Comments on the Applicant's D4 submissions

This document sets out the comments on the Applicant's Deadline 4 (D4) submissions by Cambridgeshire County Council (**CCC**), Huntingdonshire District Council (**HDC**) and South Cambridgeshire District Council (**SCDC**) (together, the **Councils**). The tables below set out the document in question that the Councils are commenting on, together with the relevant paragraph or reference number.

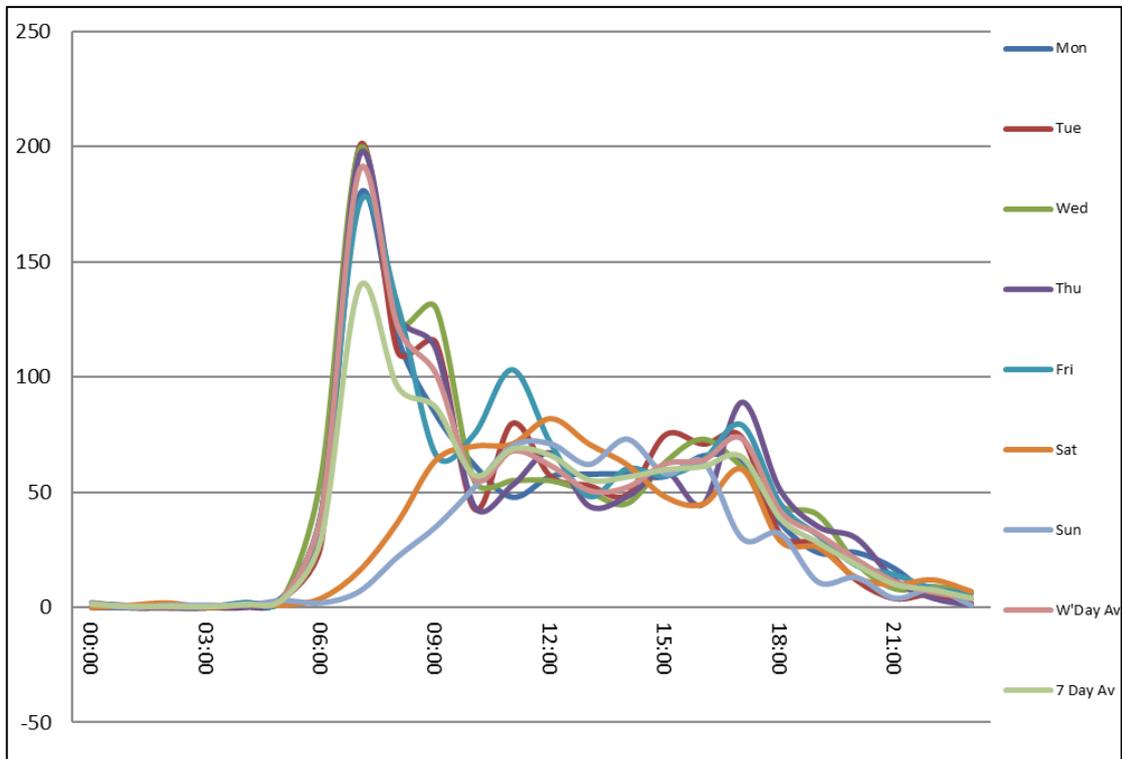
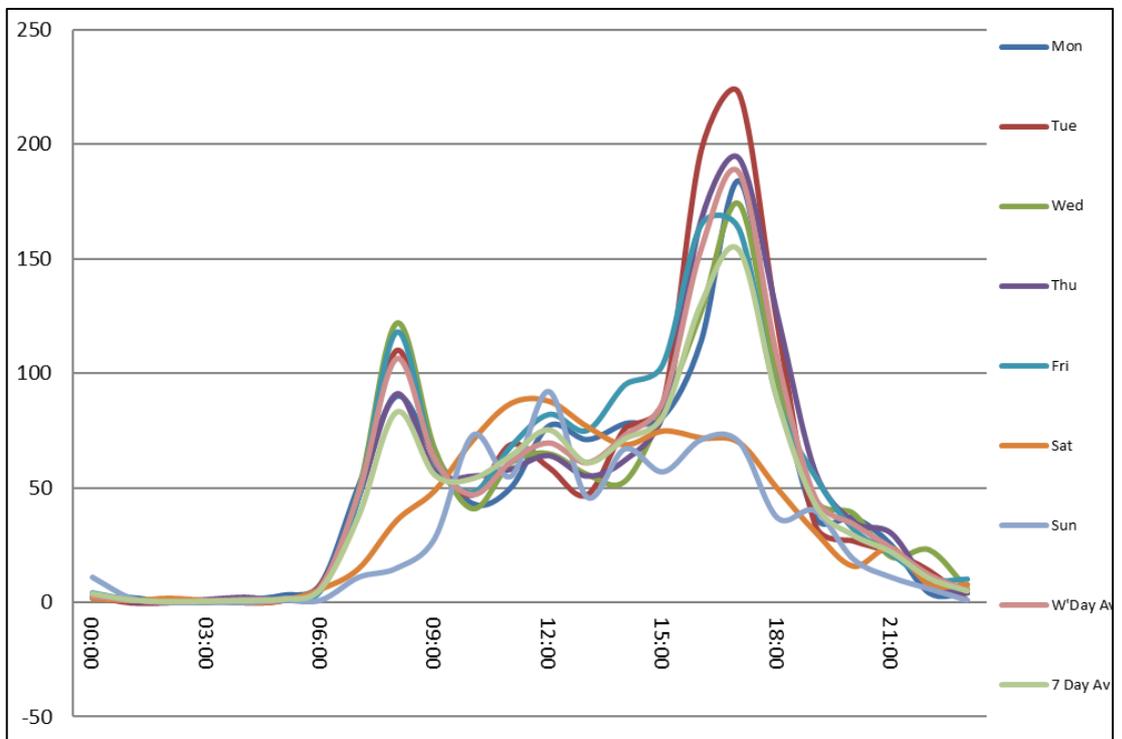
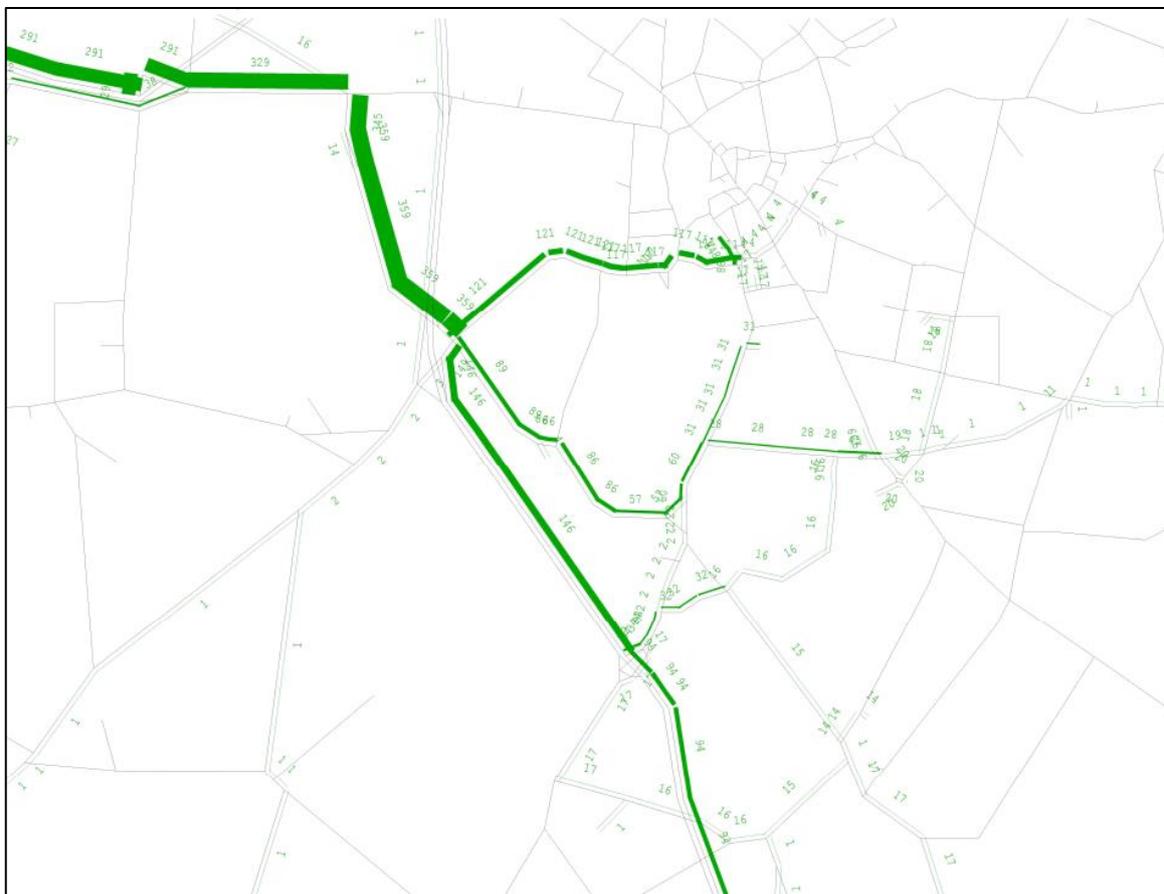
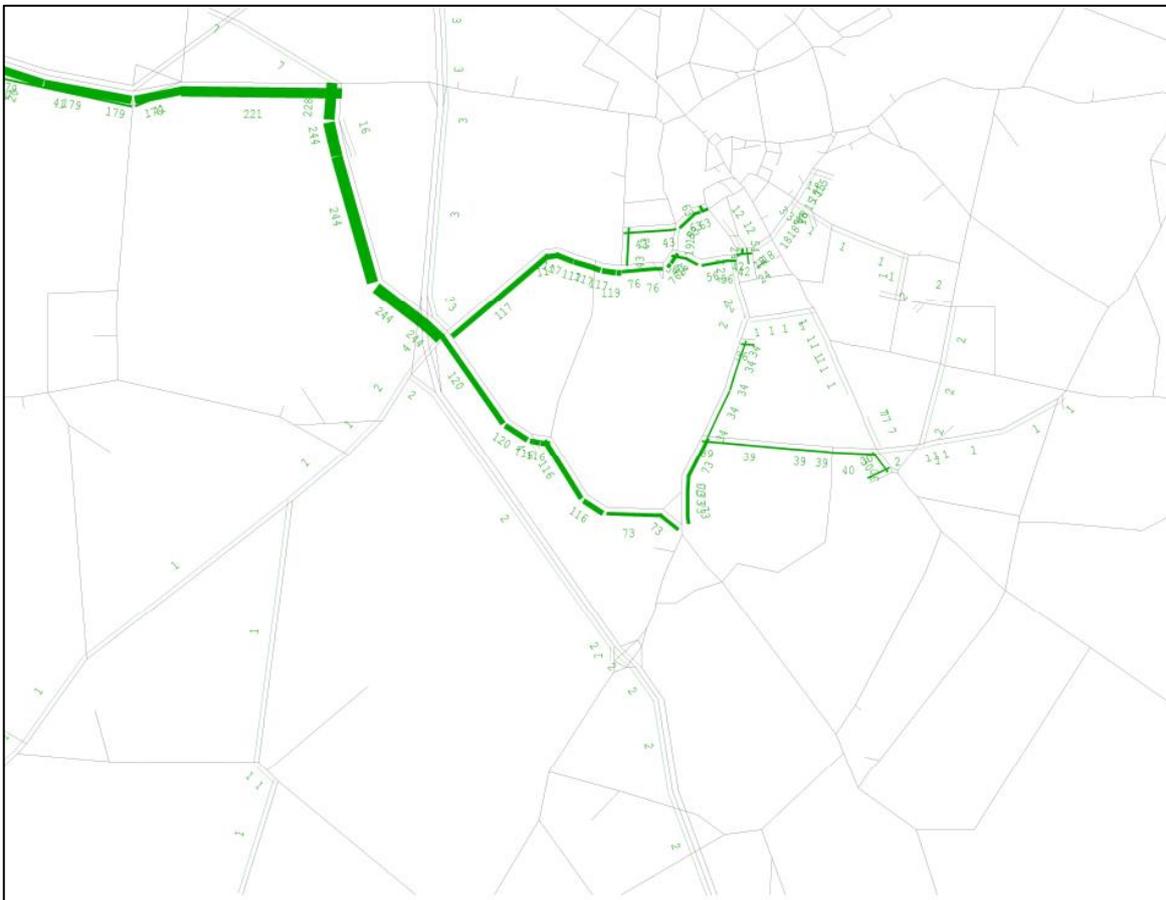
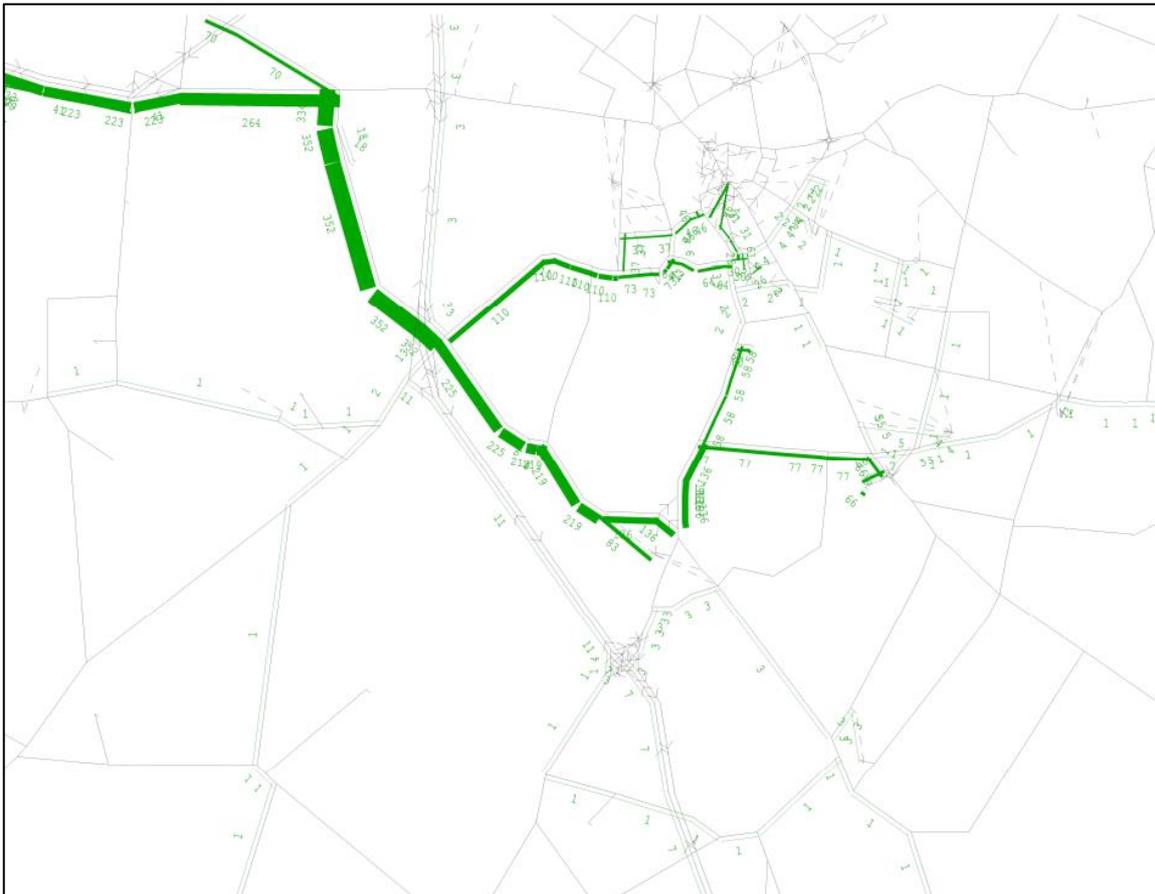
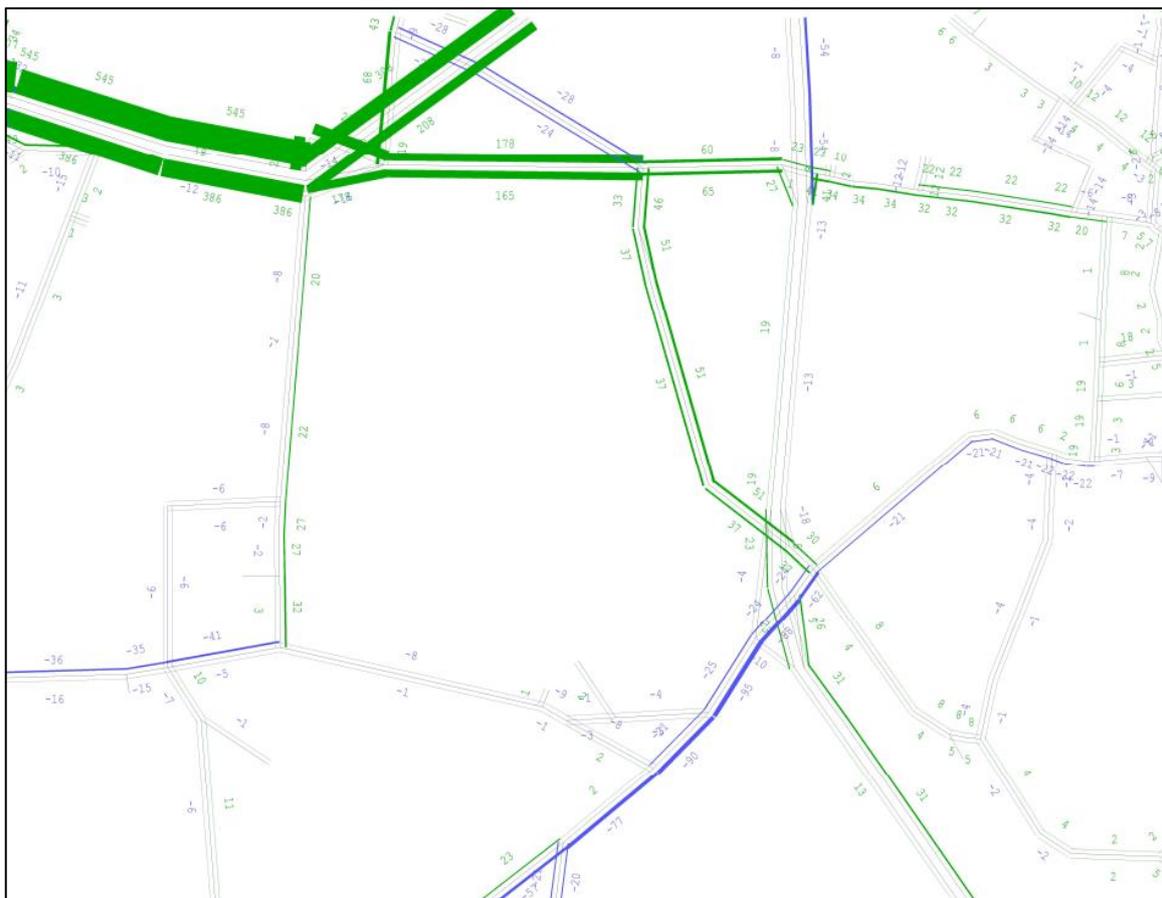
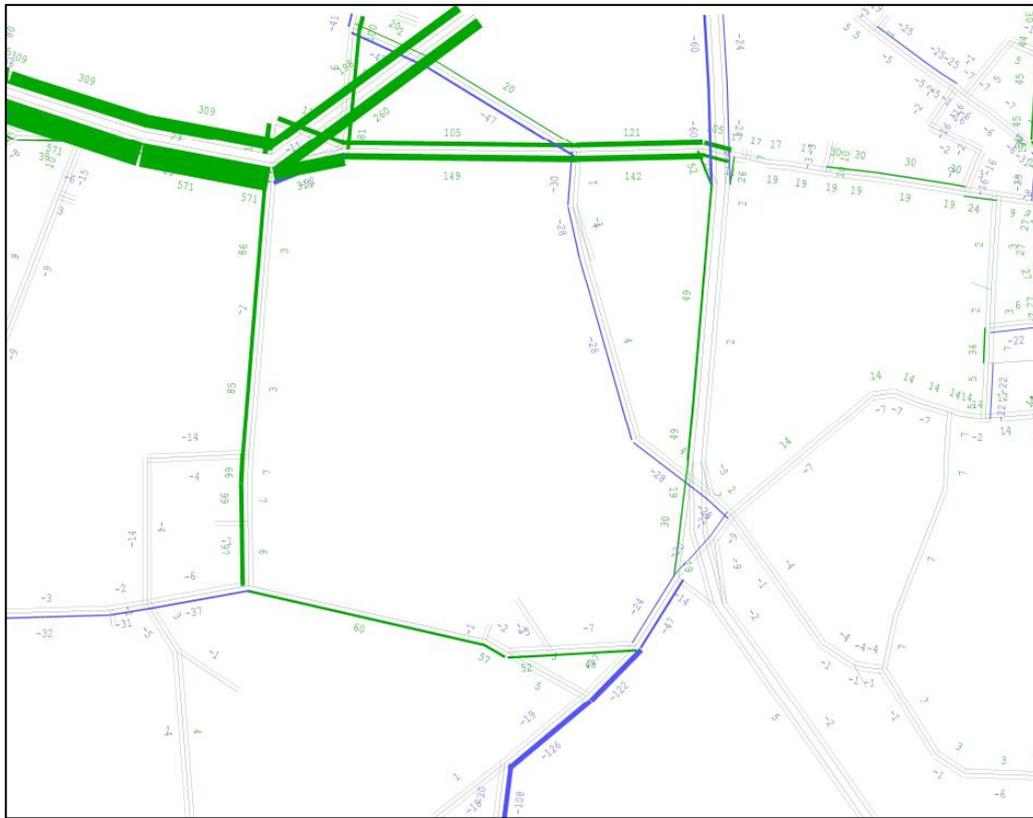
Traffic Origins and Destinations and	REP3-038aa to REP3-038al	The Applicant argues that the issues with the model are due to traffic in the model using all routes available. However, the reason that the volumes of traffic through Coton are as they
